Tel: 01903 737756
Email: planning@arun.gov.uk
www.arun.gov.uk/planning
Please ask for: Mrs D Johnson
Email: daun.johnson@arun.gov.uk
Telephone: 01903 737762
Our Ref: A/53/26/PL
Your Ref:
Date: 27th April 2026

Application for Planning Permission

Development: Change of use of buildings and canopies from shop and cafe to a flexible use of agriculture or Class E a), b), c), e), f) & g) uses. This application is in CIL Zone 3 (Zero Rated) as other development.

Location: Roundstone Farm Littlehampton Road Ferring BN12 6PW

ROUNDSTONE FARM
SHOP & CAFE
EXISTING / PROPOSED
BLOCK PLAN / ROOF PLAN
SCALE: 1:500

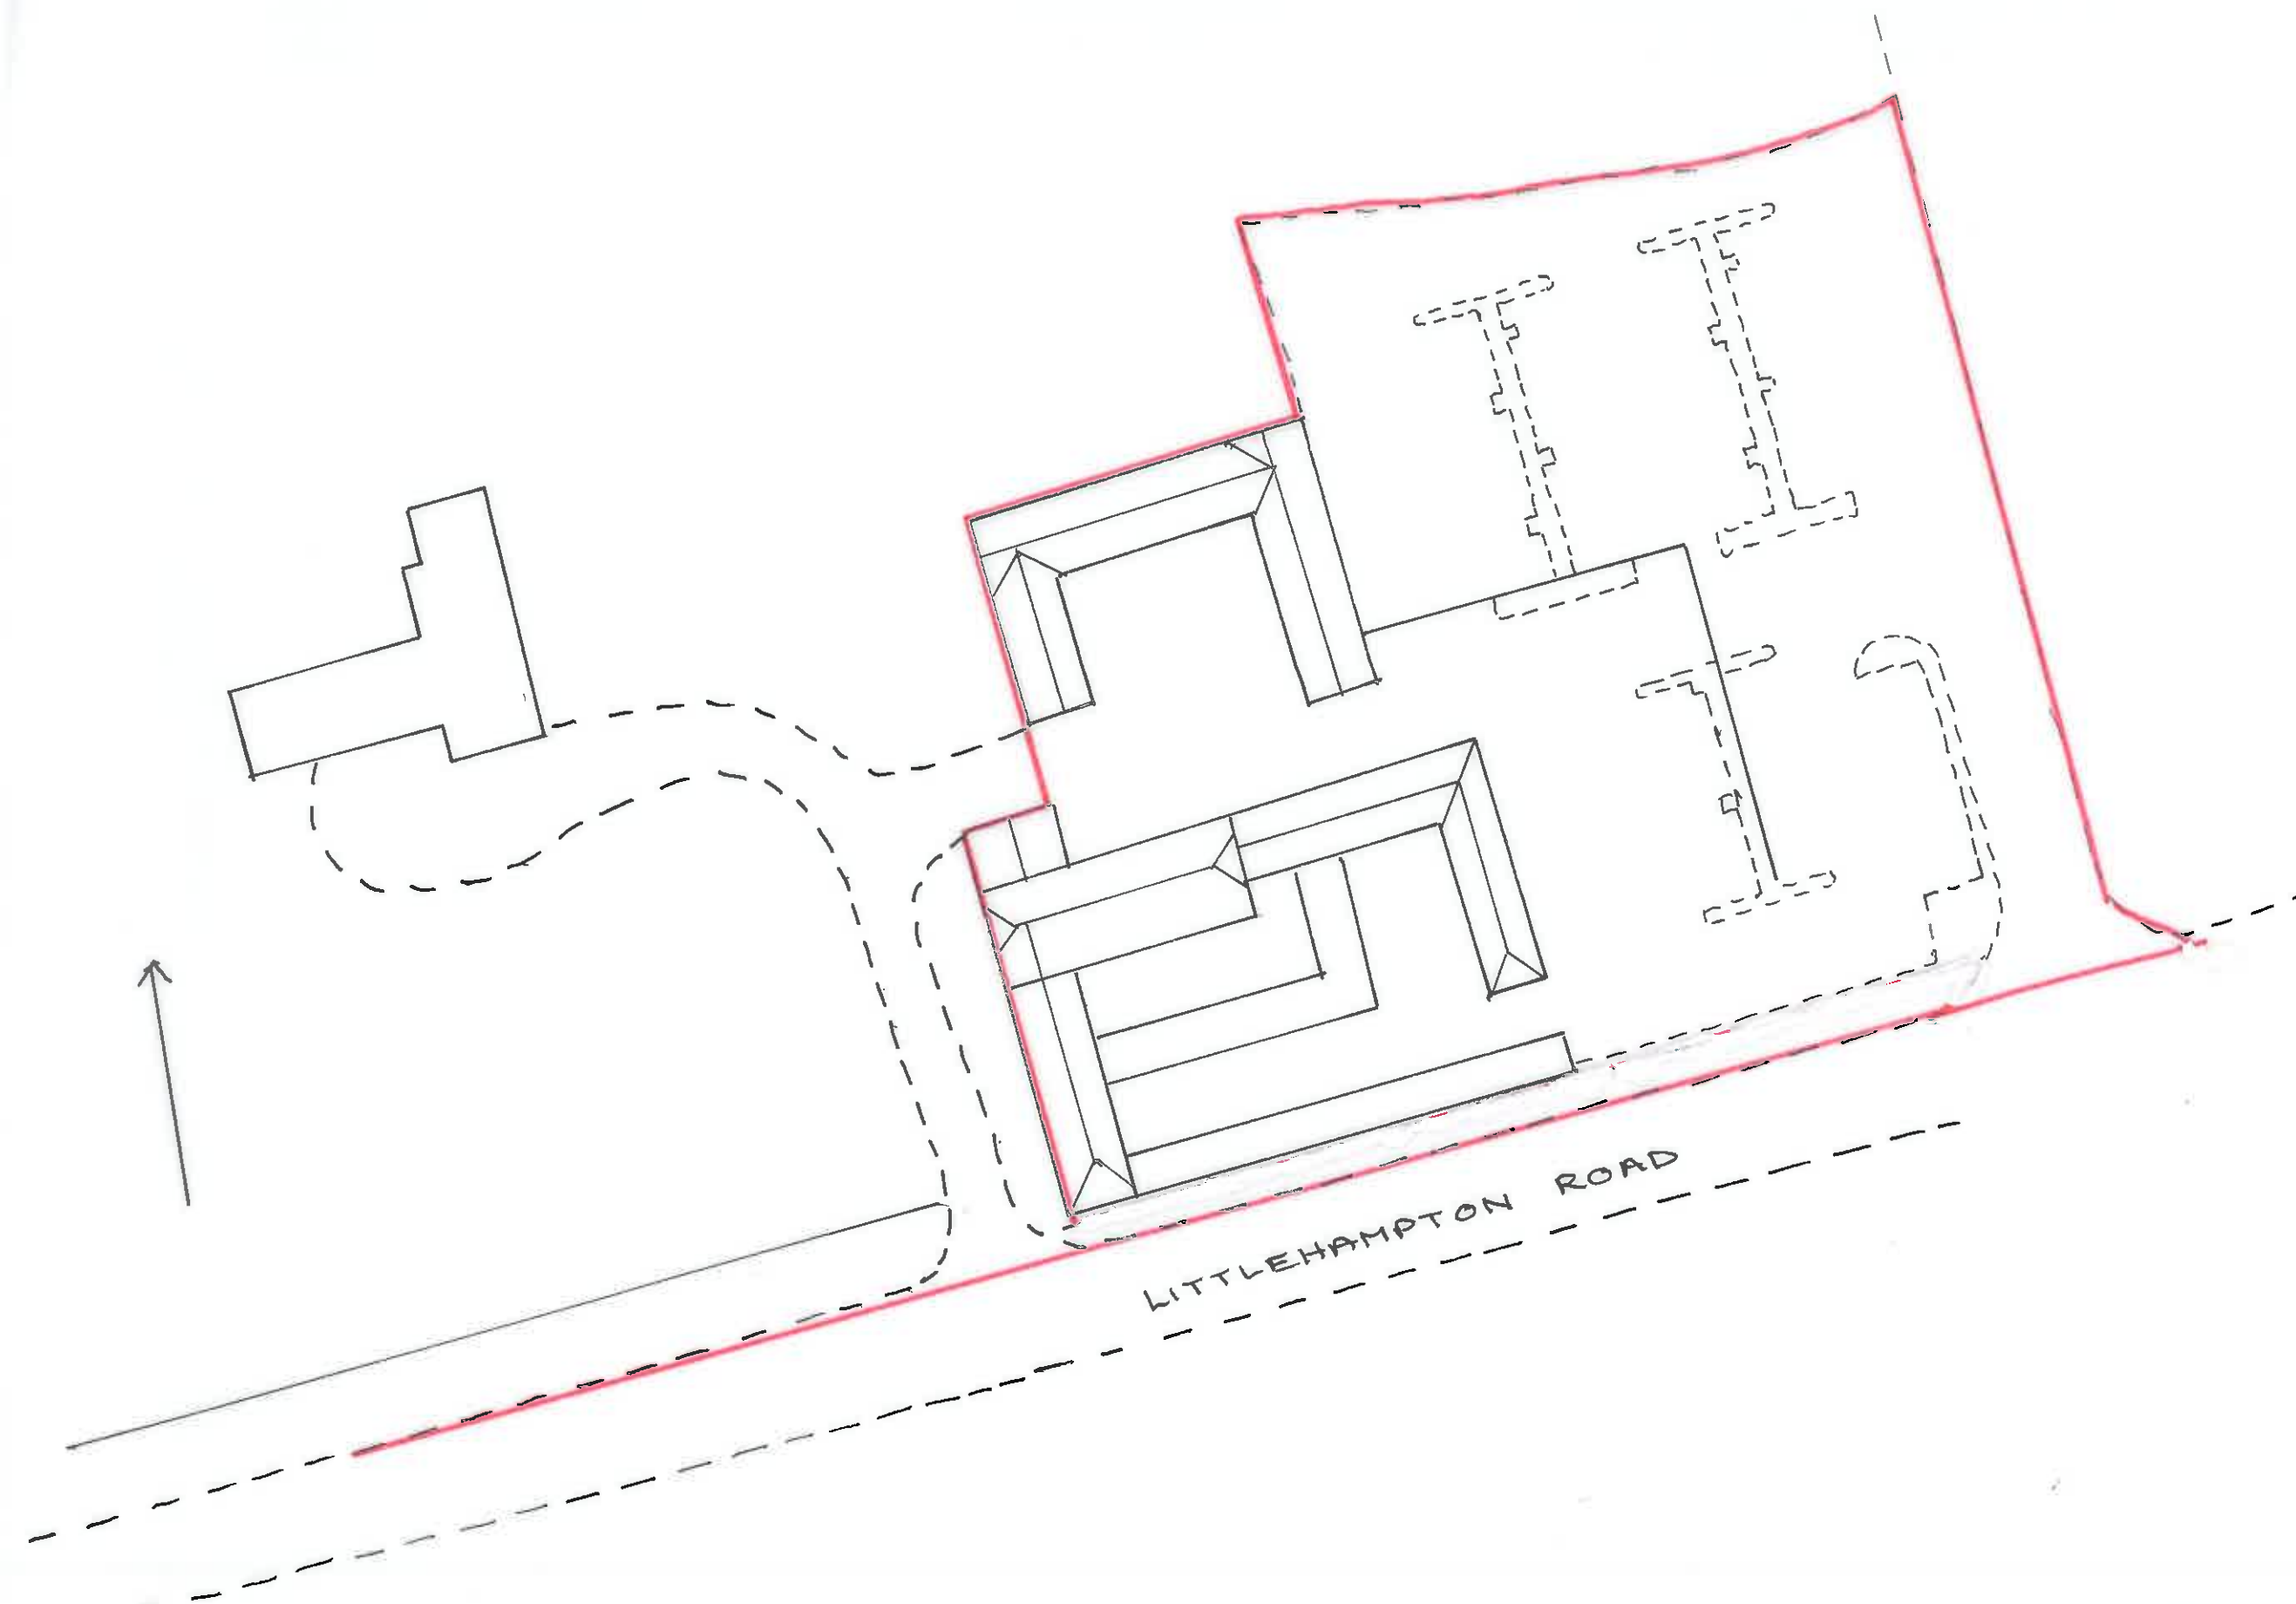
Block Plan

Please highlight the proposed works.

Roundstone Farm Shop and cafe, BN12 6PW

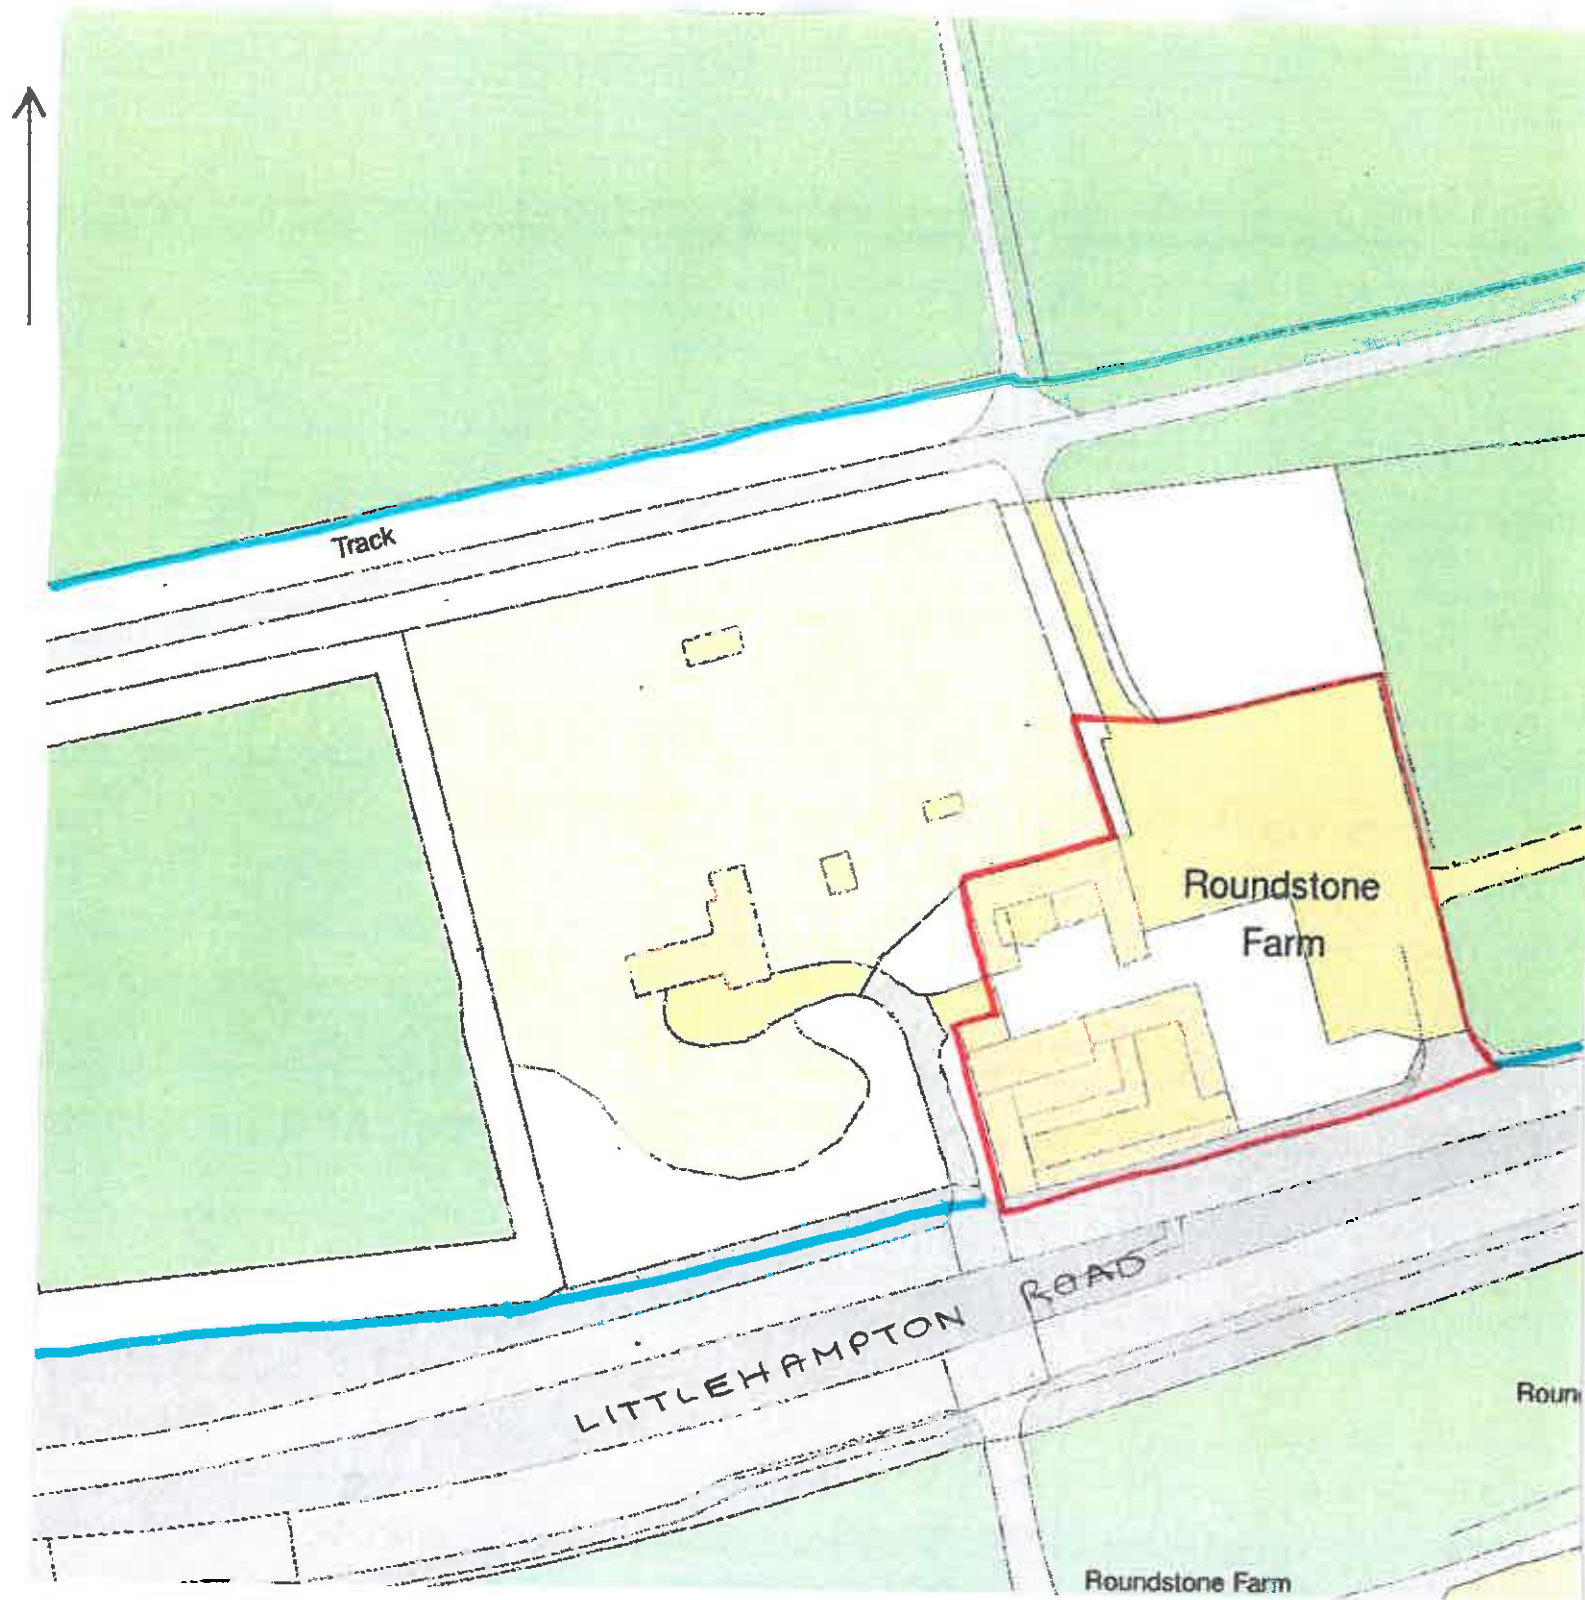
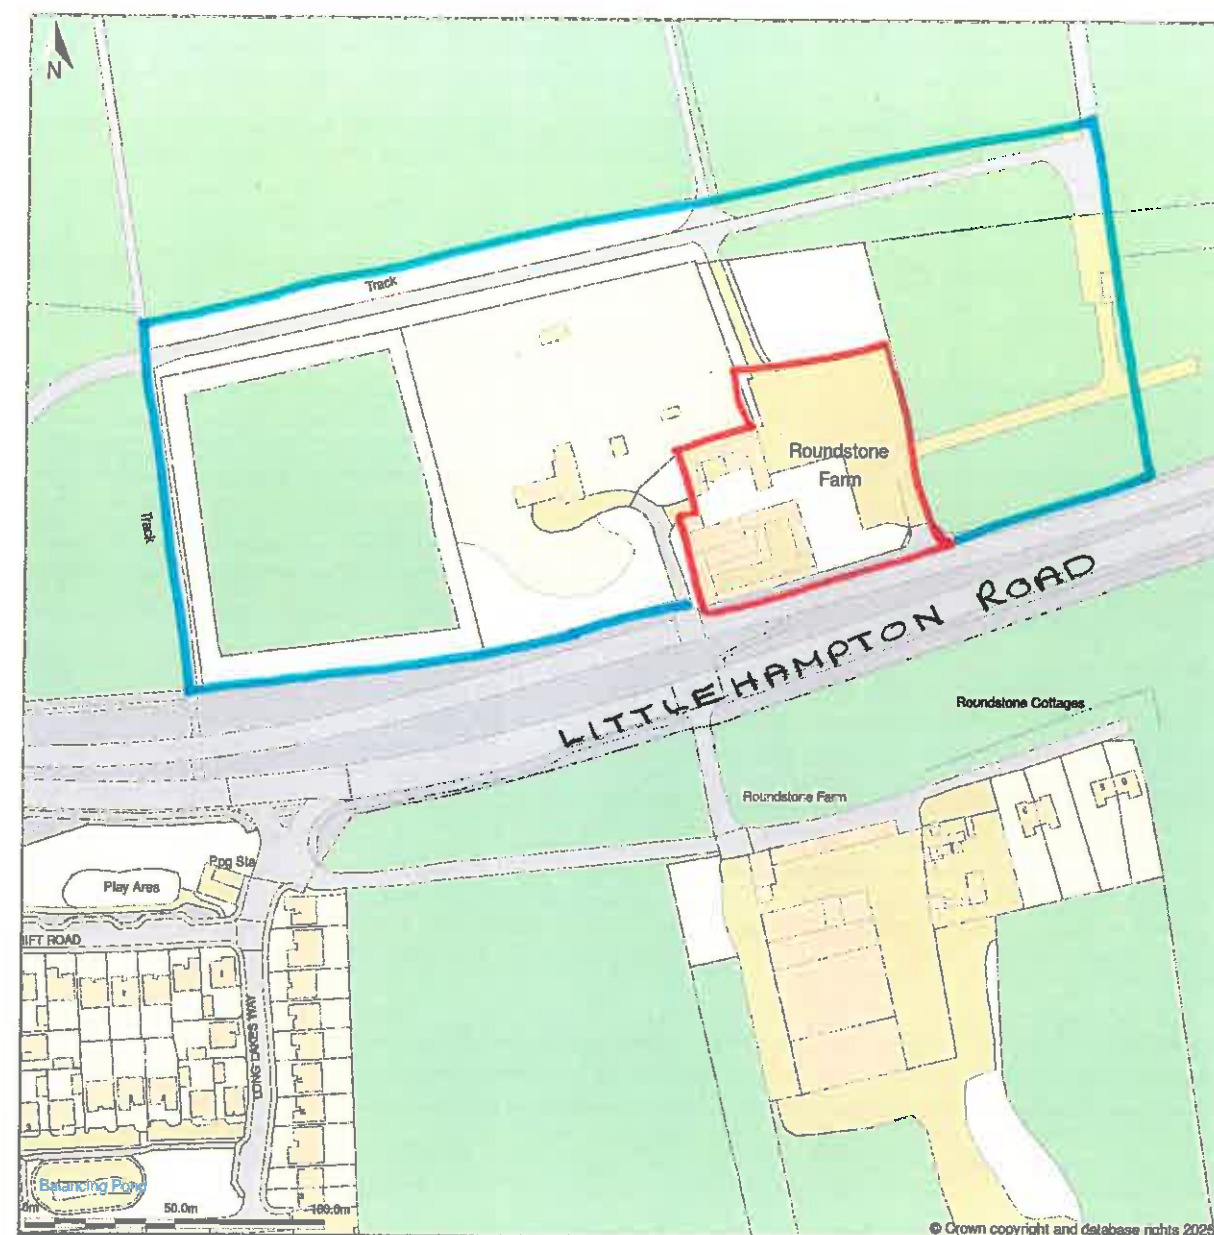
Location Plan

Please provide one named road and a full blue edge.
